**Application no:** H02-0902-09

**Description:** Ground floor extension and alterations

**Amendment:** Amended shape and size of rooflights (dwg. nos.  
2008-09-03B and 2008-09-04B)

### ACKNOWLEDGEMENT OF AMENDMENT

DRAWING PROPOSED & EXISTING ELEVATIONS SITE PLAN AND 3D VIEW  
JOB REF 2008/09 DRAWING NO 04B DATE OCT 2009 DRAWN JPW  
SCALES 1/50 1/200 AND NO SCALE TO 3D VIEW

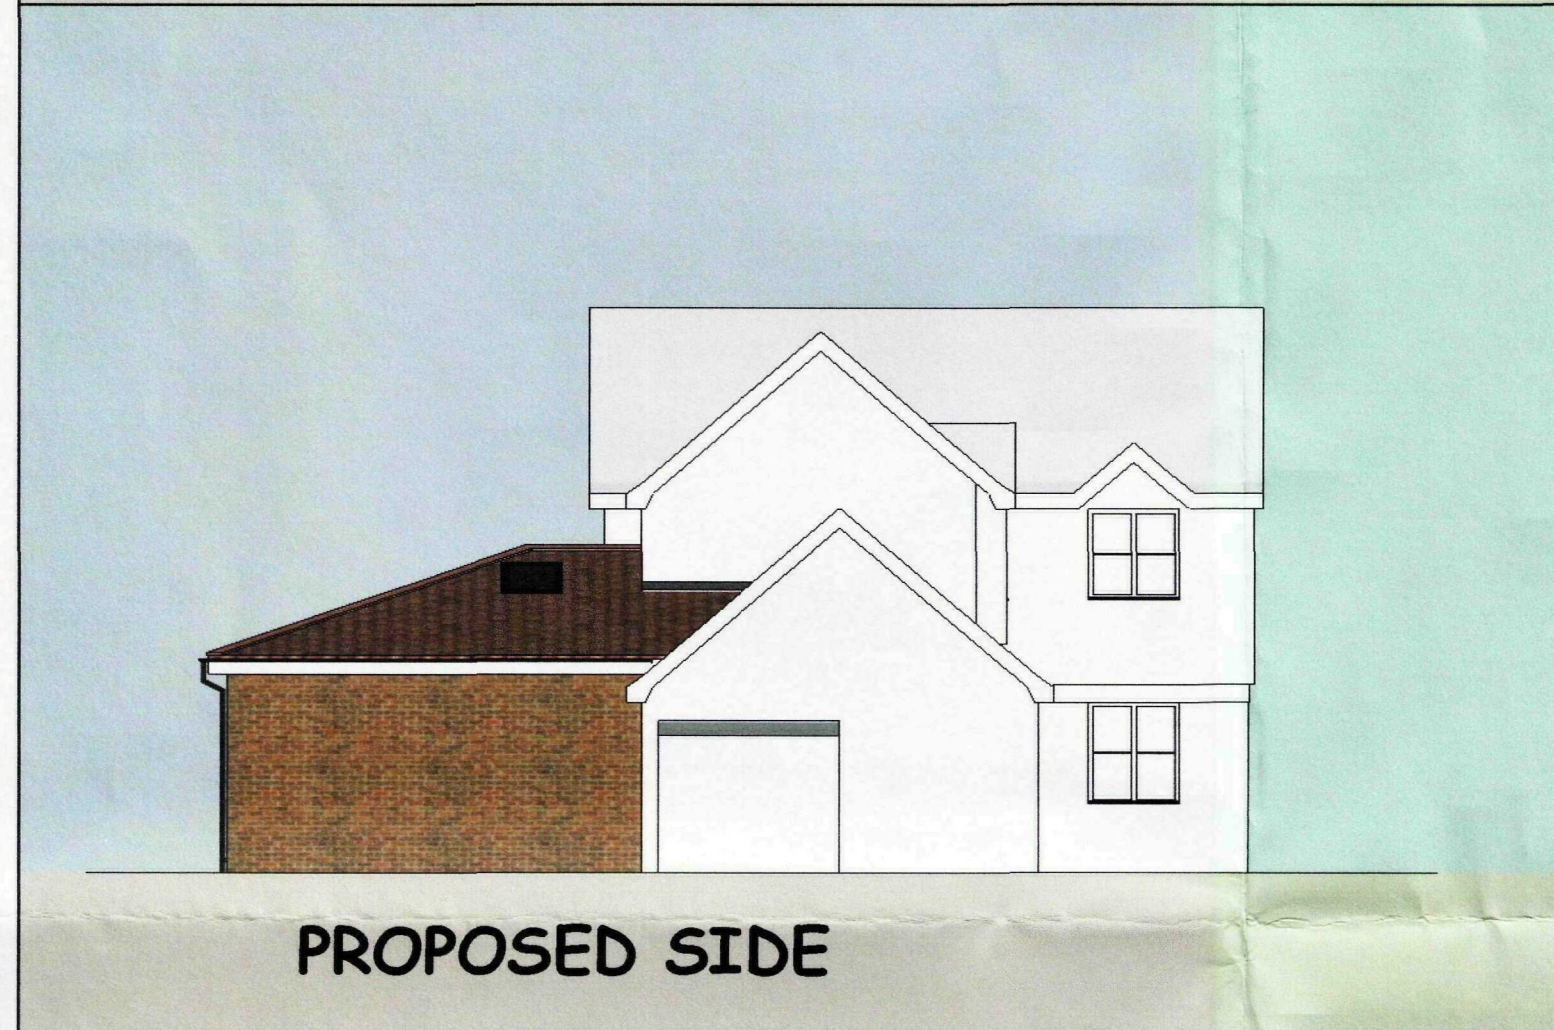
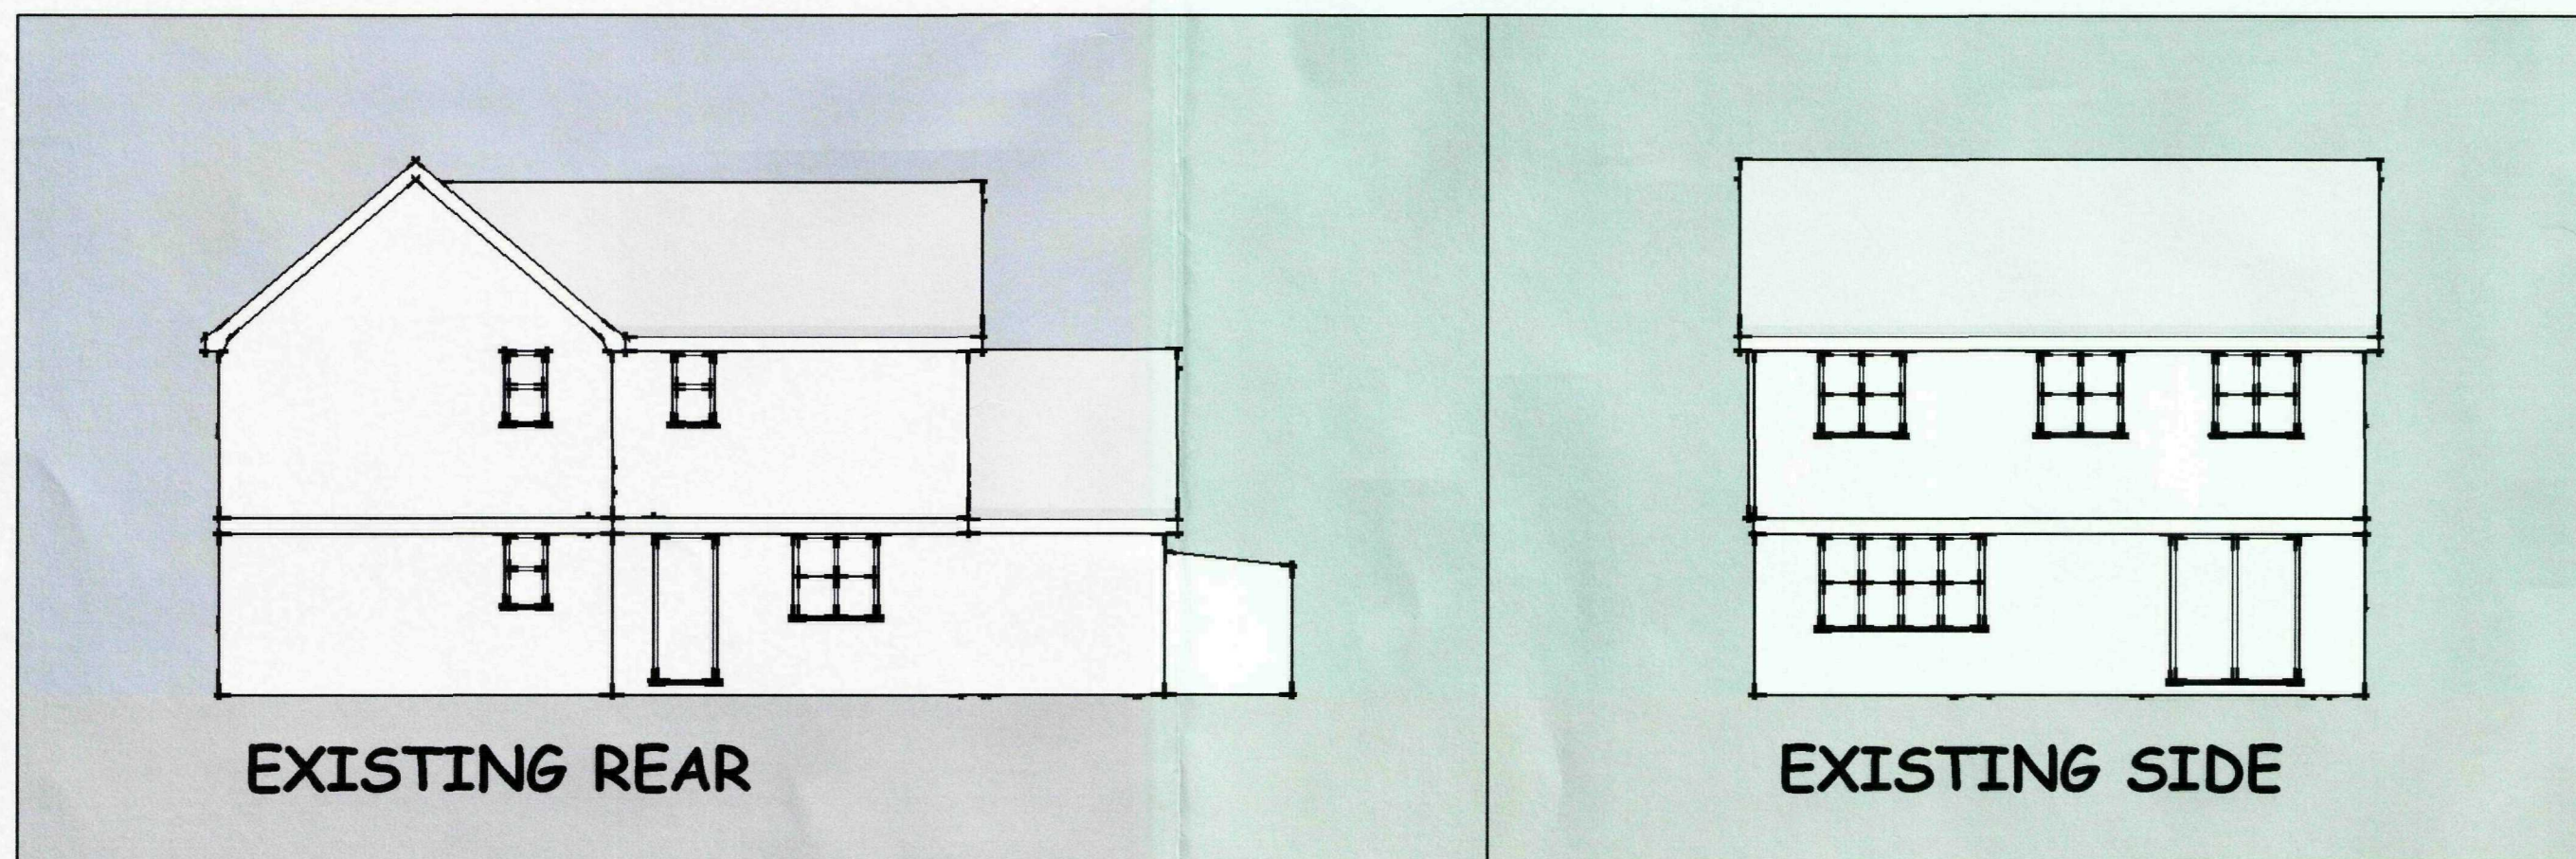
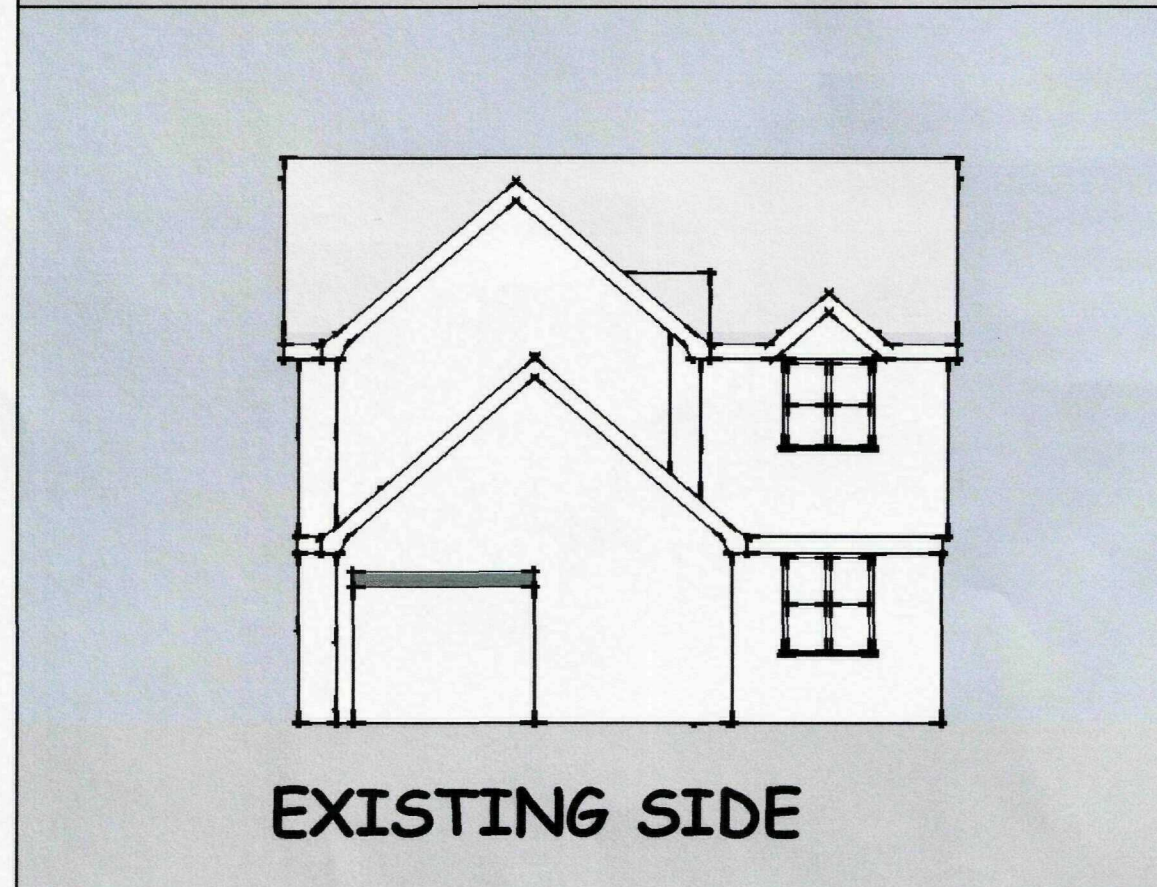
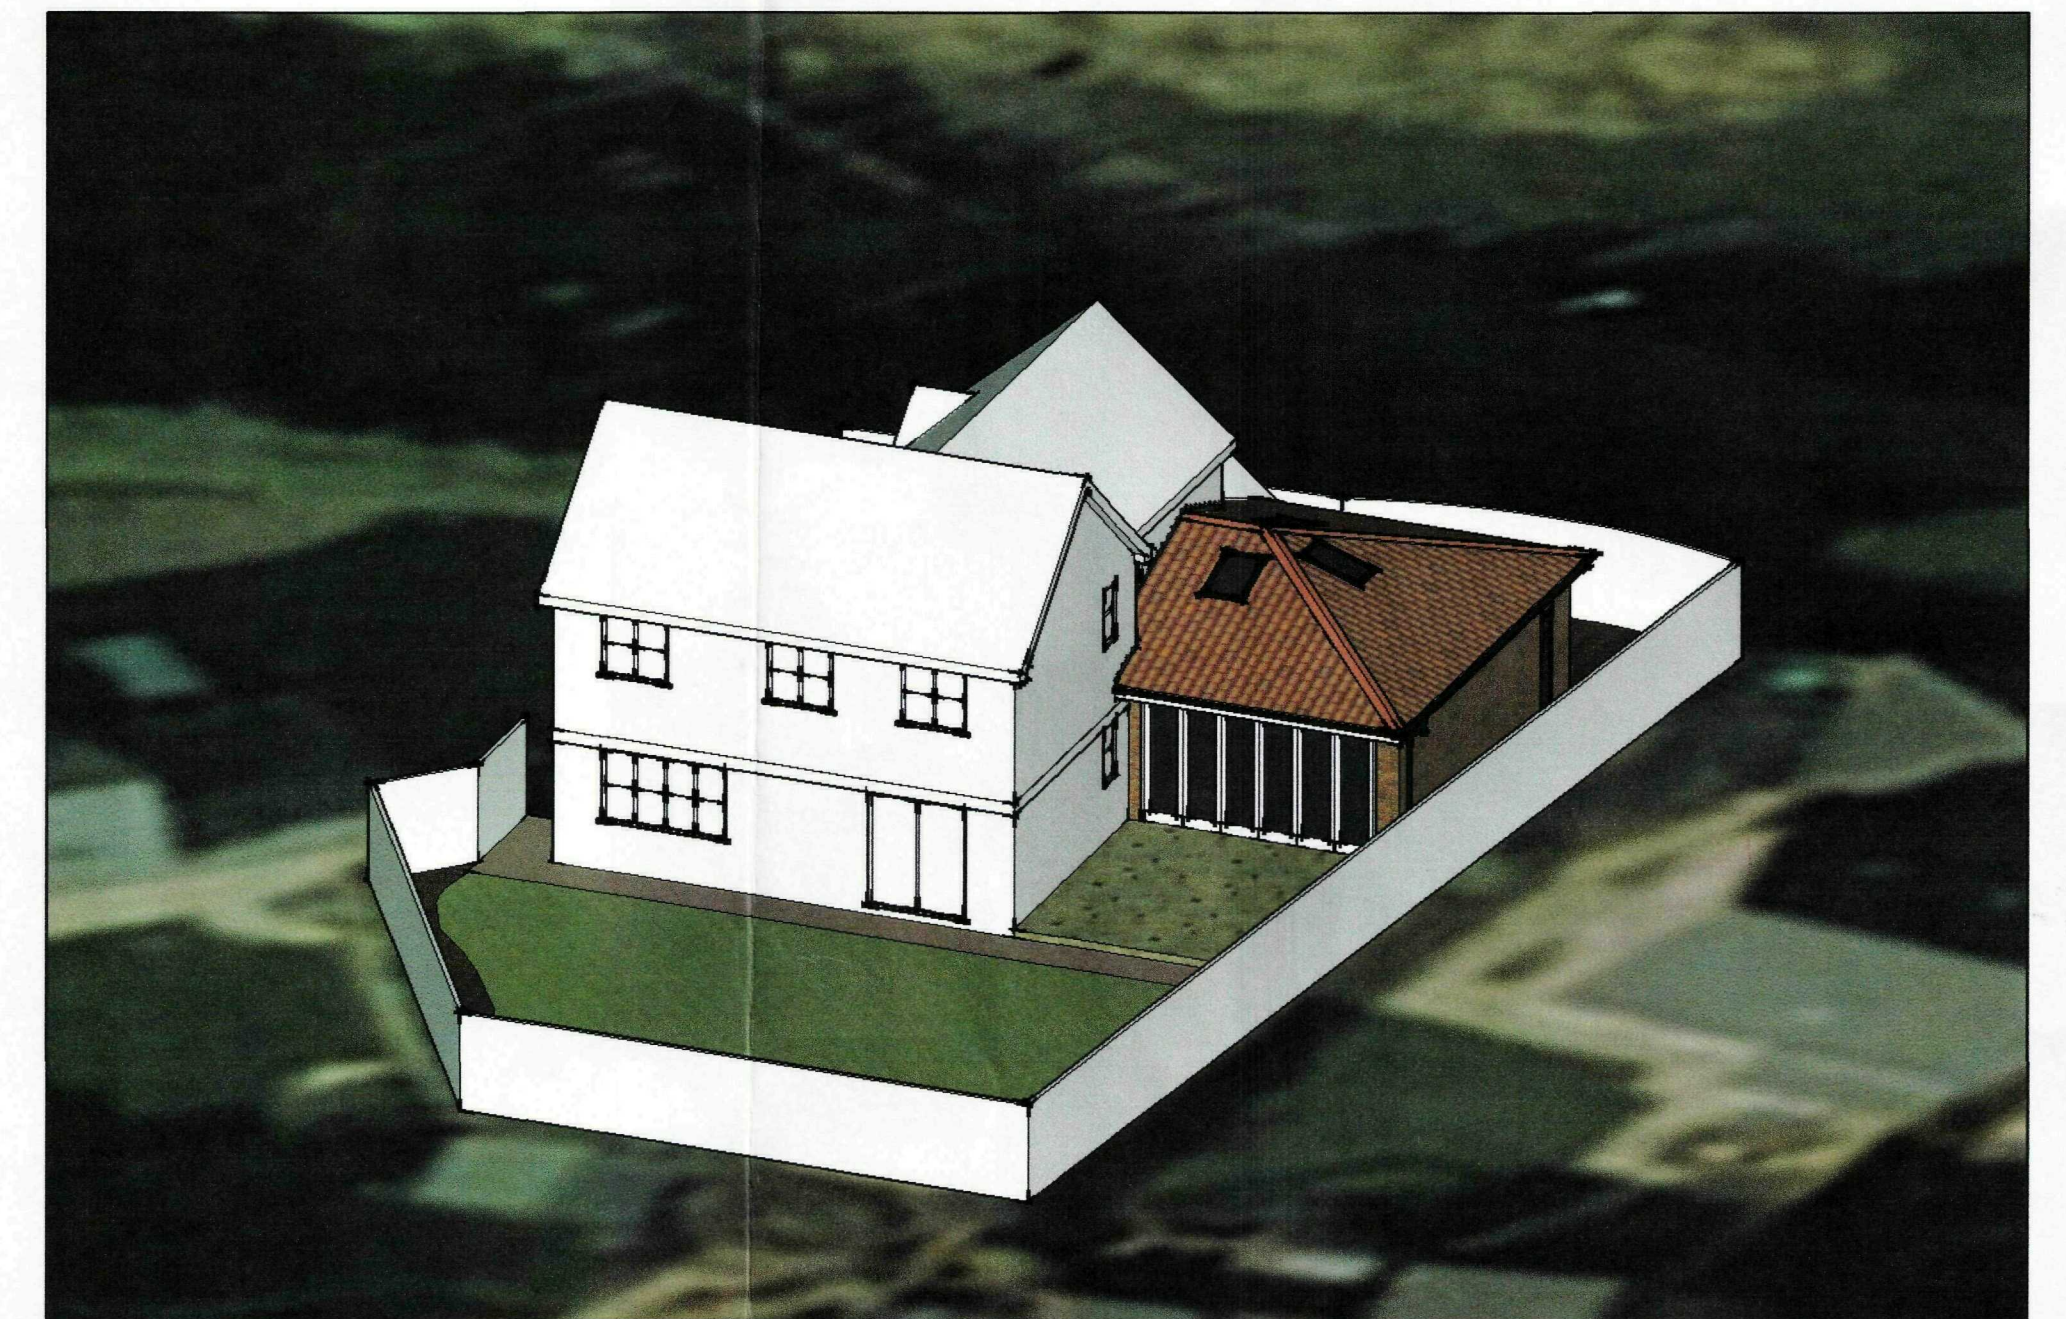
With reference to the above please find enclosed 2 No copies of amended plans as our clients have changed the shape and size of the rooflights on the extension.
